250 Commercial Street Permit #2016-03039

I am the Head Distiller at Liquid Riot as well as the person who is planning this storage room. The answers to your questions are below.

A1.01

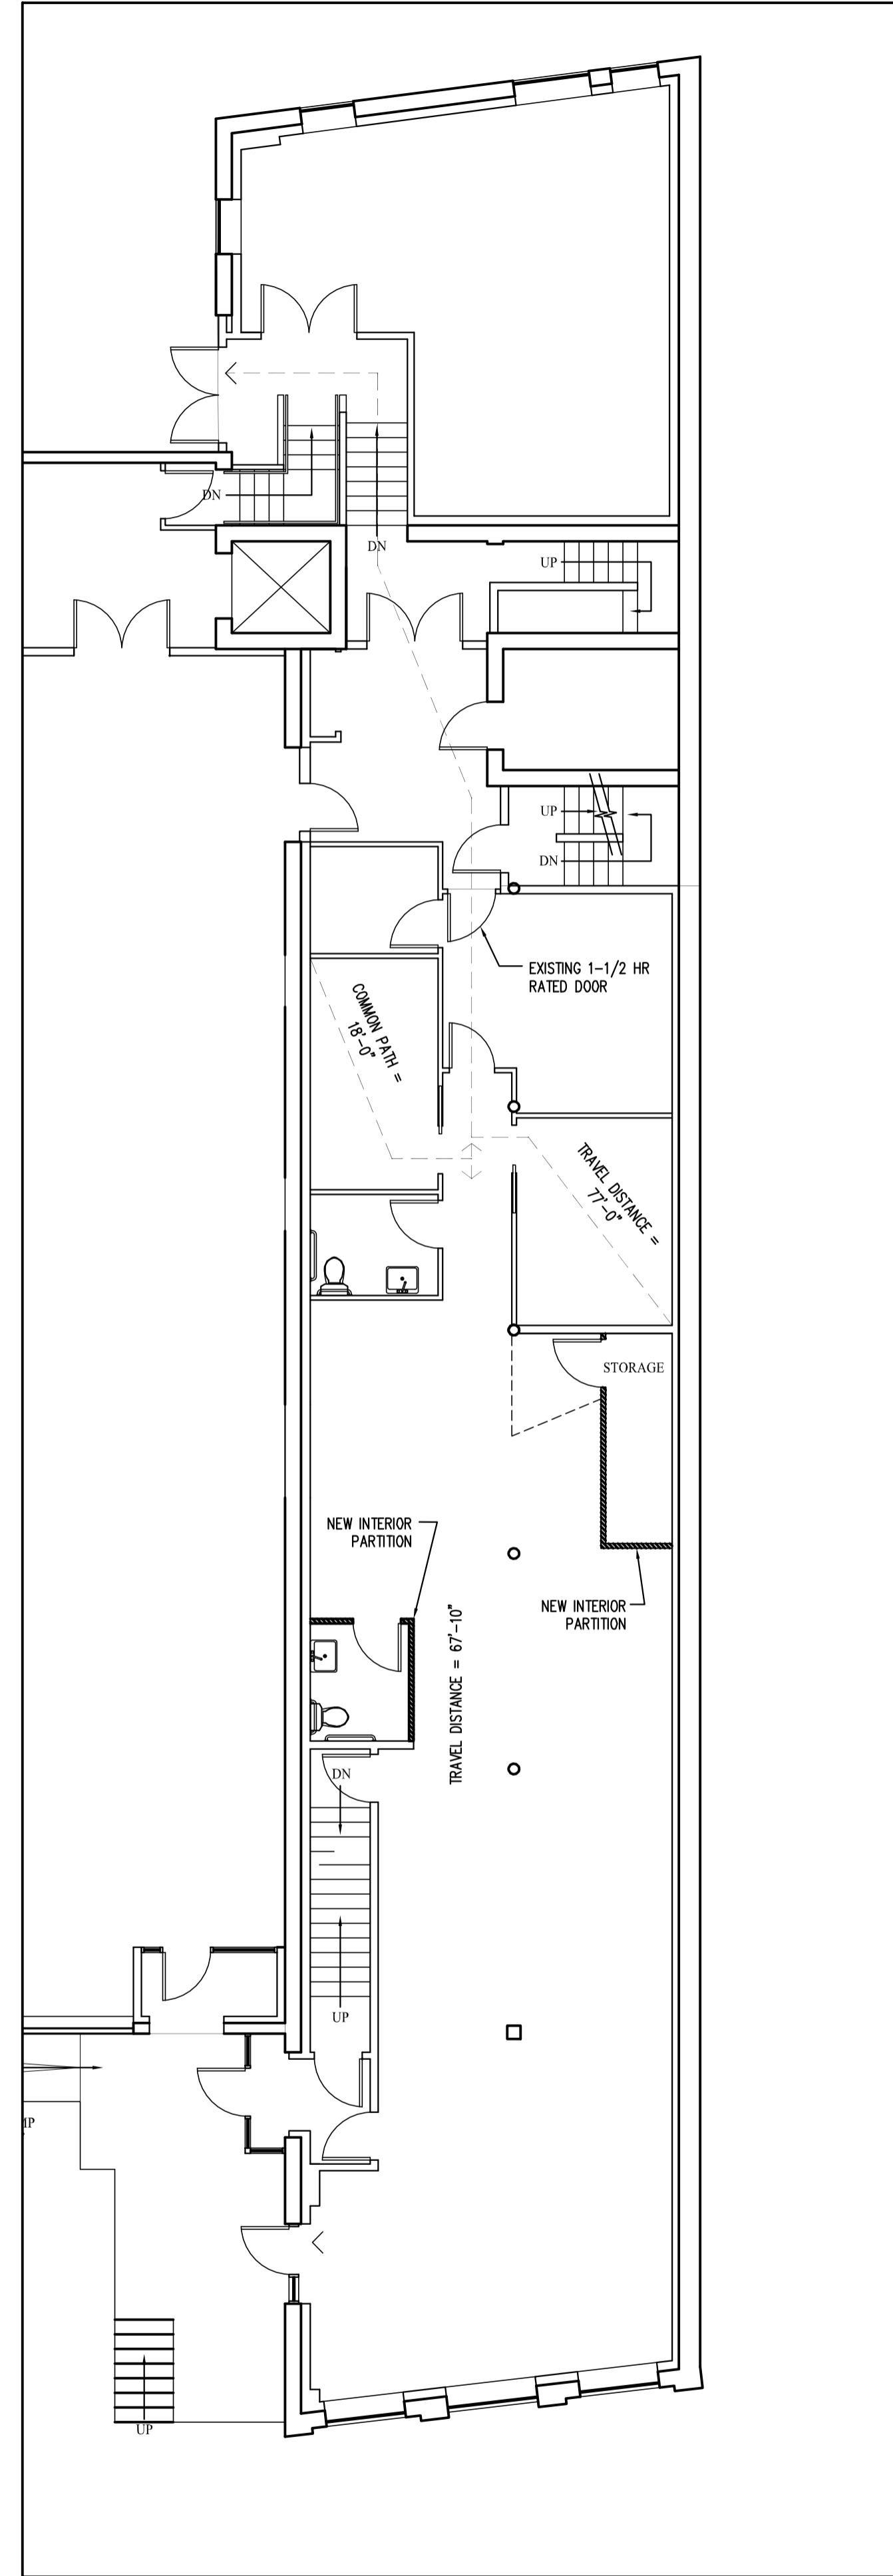
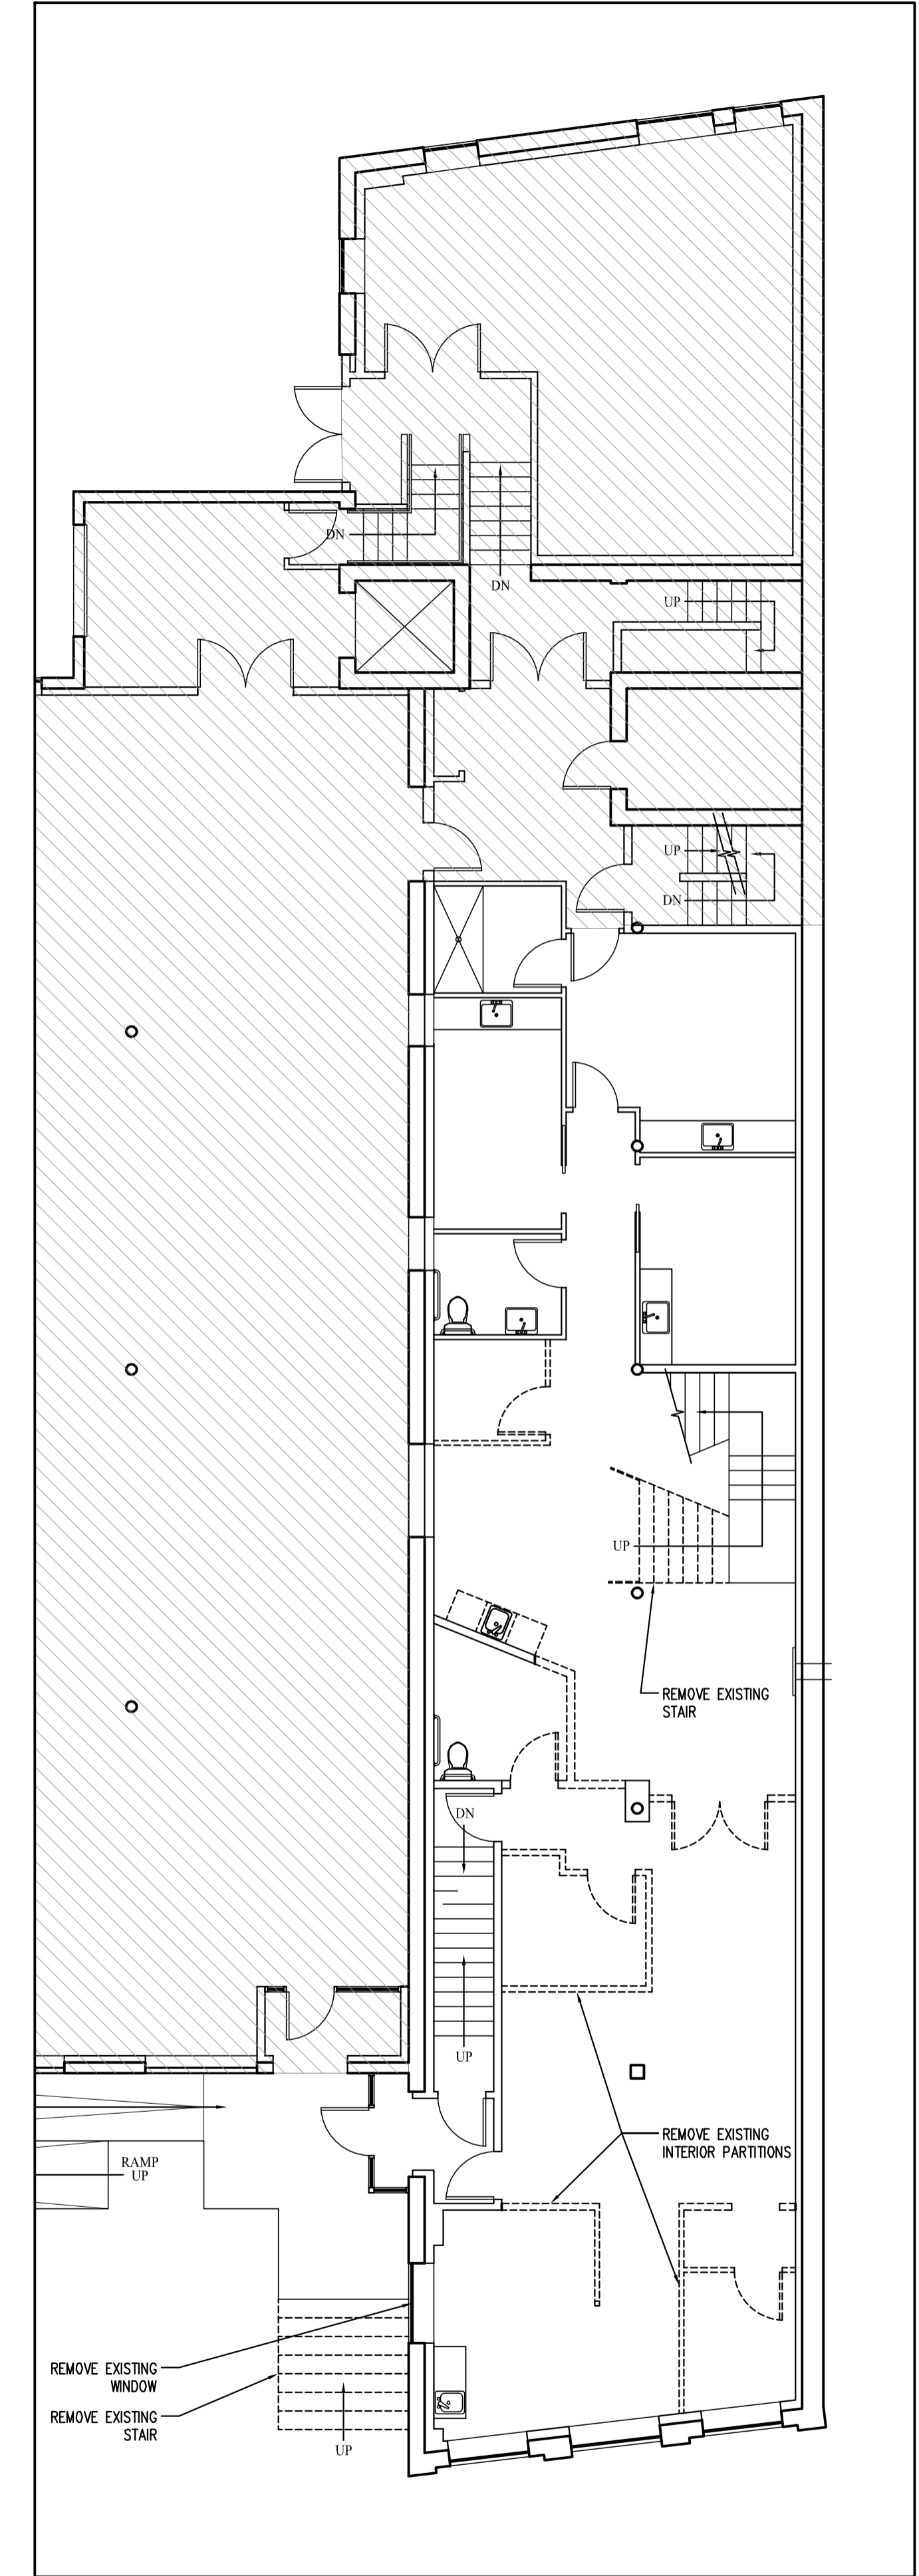
2. the proposed size or square footage of the storage room and size of the door for the room.

3. I can not tell the location of the proposed walls in relation to the the fire sprinkler system heads in the area. depending on there locations this my cause an obstruction to the heads which will need to be corrected by a licenced fire sprinkler contractor before your final inspection. I do not need any information on this I just wanted to let you know that this will be a condition on your permit when it is completed.

The proposed room dimensions are 15'-6" x 29'-3", so 5440.5 sq ft. The proposed door is standard metal, 1hr fire rated, 5' wide x 6'-8" tall.

The proposed walls do not obstruct any sprinkler heads. There are 3 sprinkler heads contained within the proposed room. You have stated you do not need this information, but I would be happy to note the sprinkler head locations on the drawing we have submitted.
